Attention: Director, Infrastructure Projects The Department of Planning and Infrastructure

1. My name is Enrico David Pelleri, 22 Dalkeith Road, Cherrybrook, NSW, 2126
2. My Response is to EIS2 regarding NWRL Cherrybrook Station and surrounding streets
3. Application number SSI-5414
4. I reject the proposal to use Robert Road and to alter the existing Robert road to carry buses and cars to the new proposed Cherrybrook Stn on Castle Hill Road, Cherrybrook.
5. Further, I am submitting that

Figure 6.12 Cherrybrook Station - Indicative vehicle and pedestrian movements

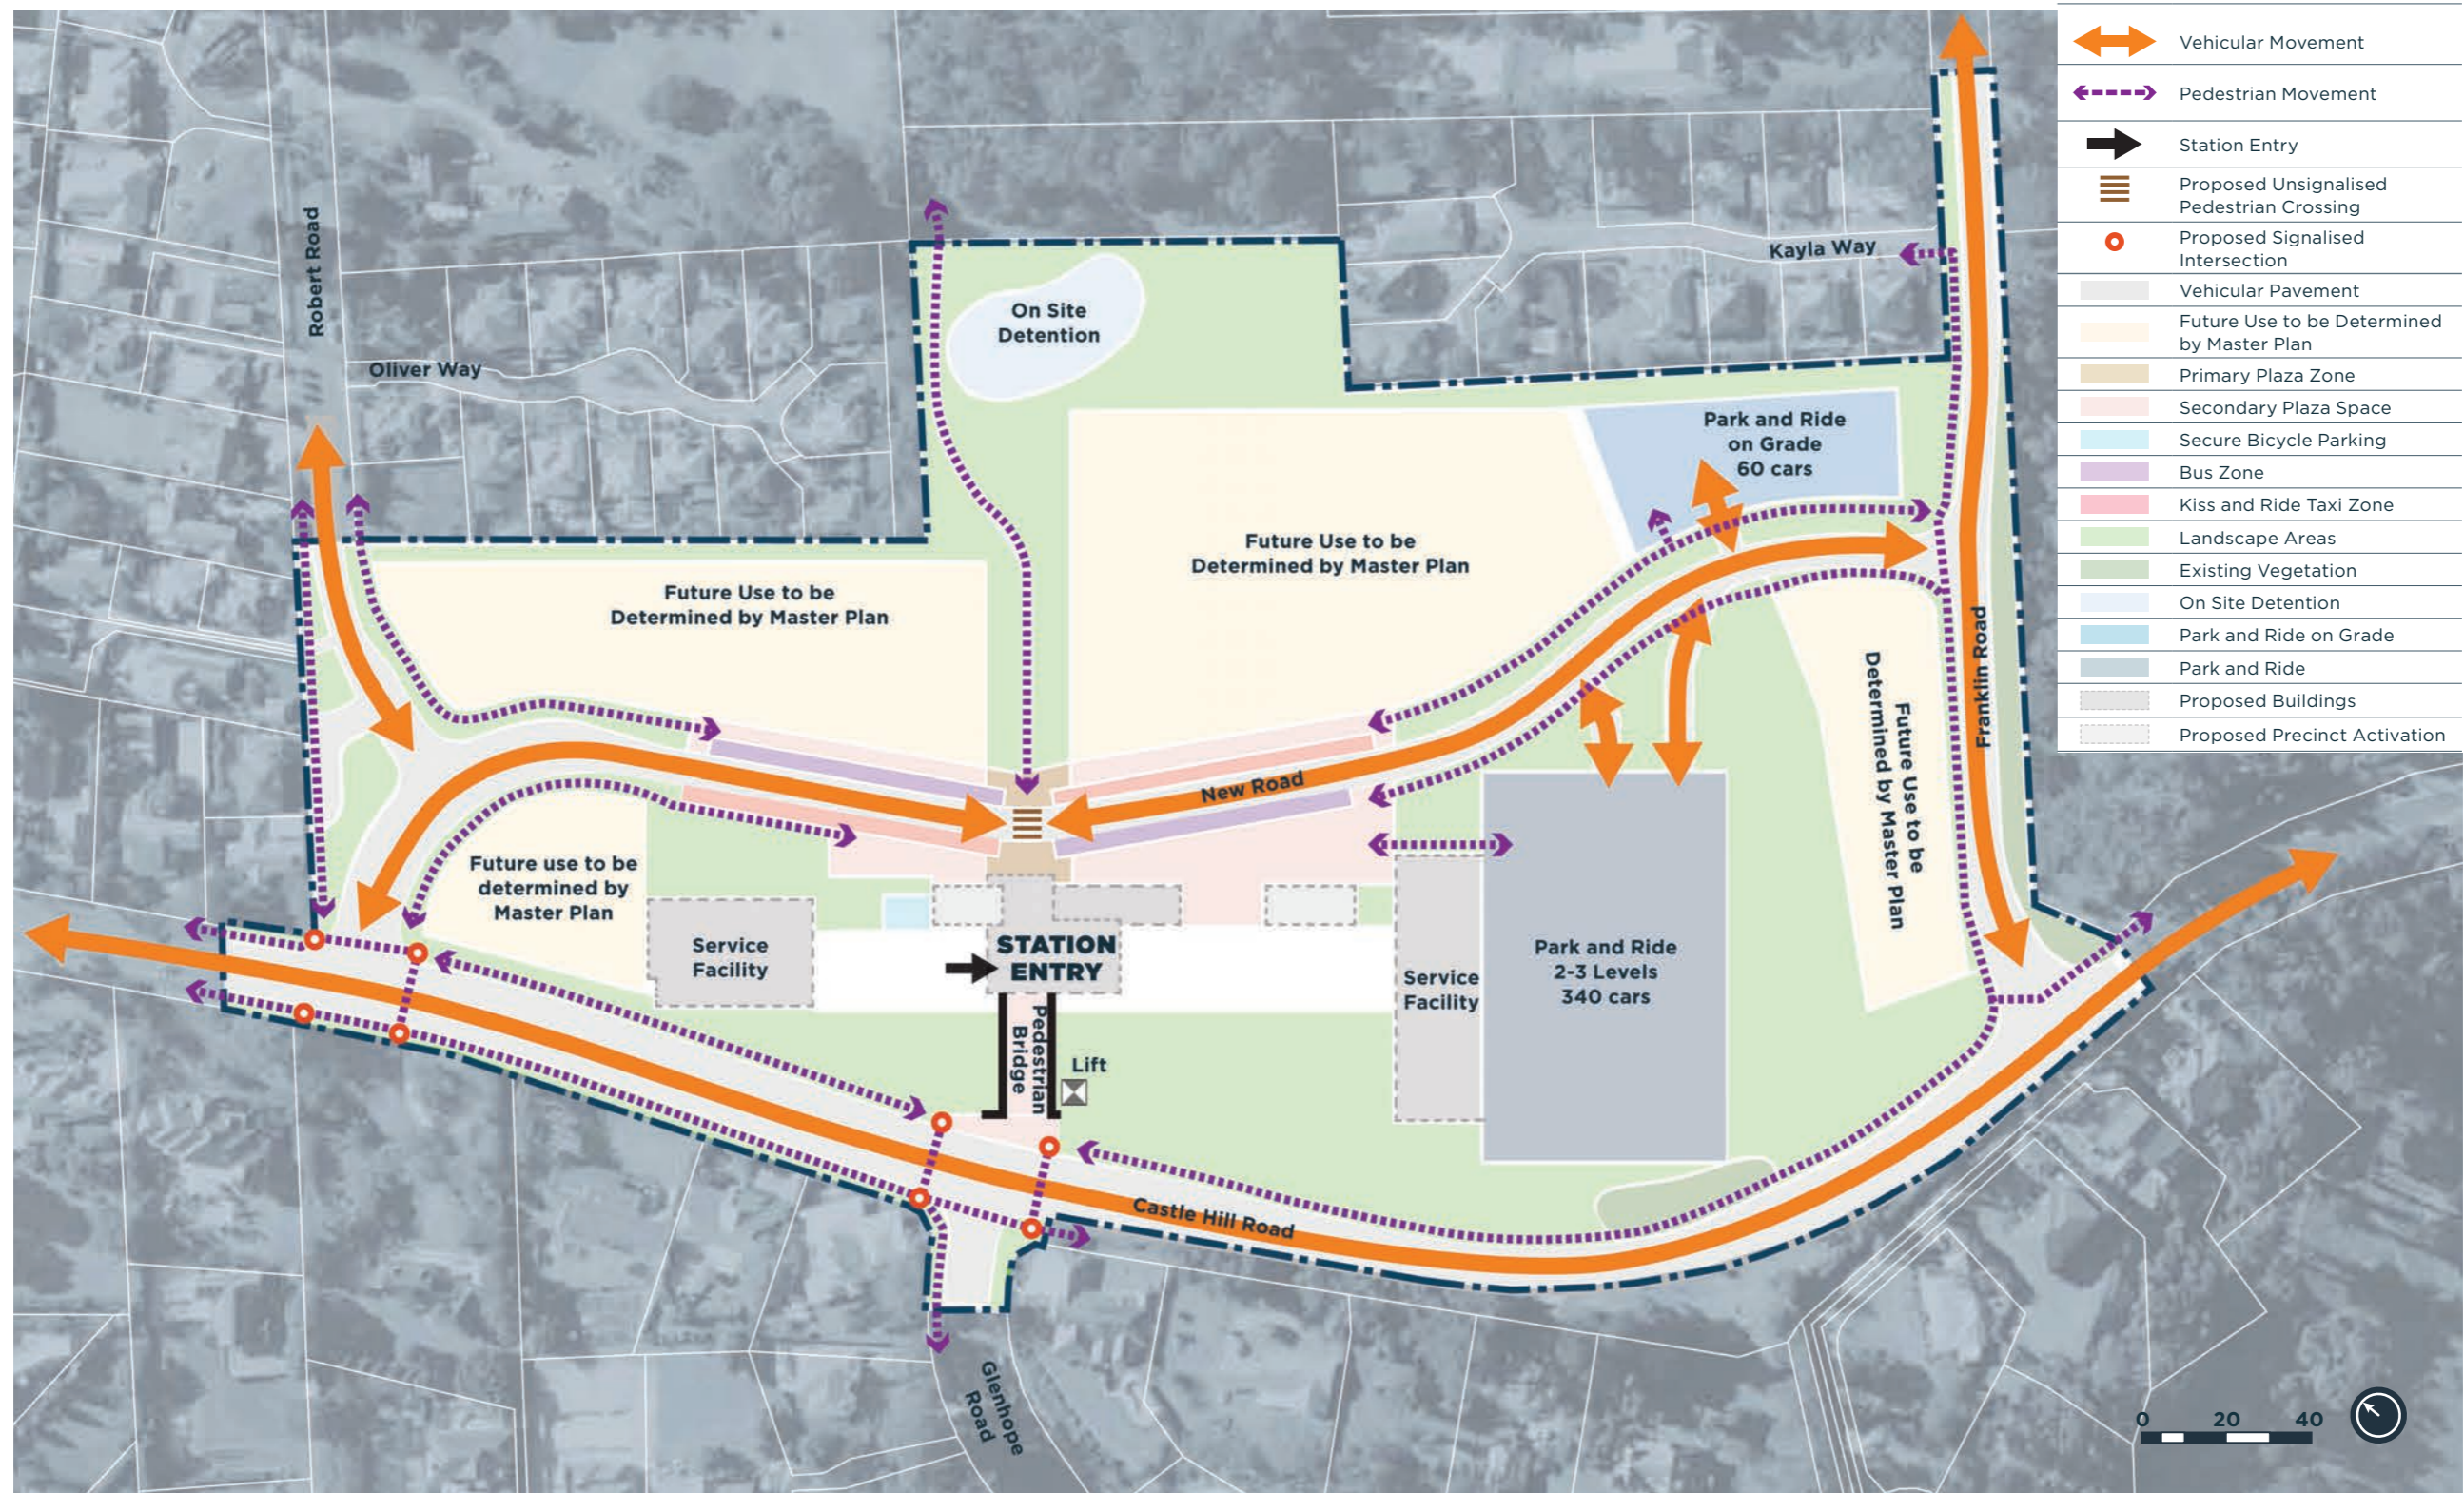
In relation to the NWRL proposal in EIS 2 of running buses south on County Drive, left into John Road and right into Robert Road, the NWRL is trying to capture commuters to and from the city who are currently situated at the bus stops on John Road between County Drive and Robert Road. These are 2 in total (1 for either direction), across the road from each other and metres away from the County Drive Bus Stop. Therefore, if these commuters were able to catch the bus situated at the County Drive Bus Stop , this would alleviate the need for buses to turn left onto John Road. The result of this small change would have a positive impact on the lives and value of properties of some 265 residents on Robert Rd and the surrounding streets.

There is the possibility to open up a bus lane on County Drive in either direction to cater solely for buses that need to access the Cherrybrook Station, thereby avoiding the potential for buses to get "gridlocked" in peak hour traffic.
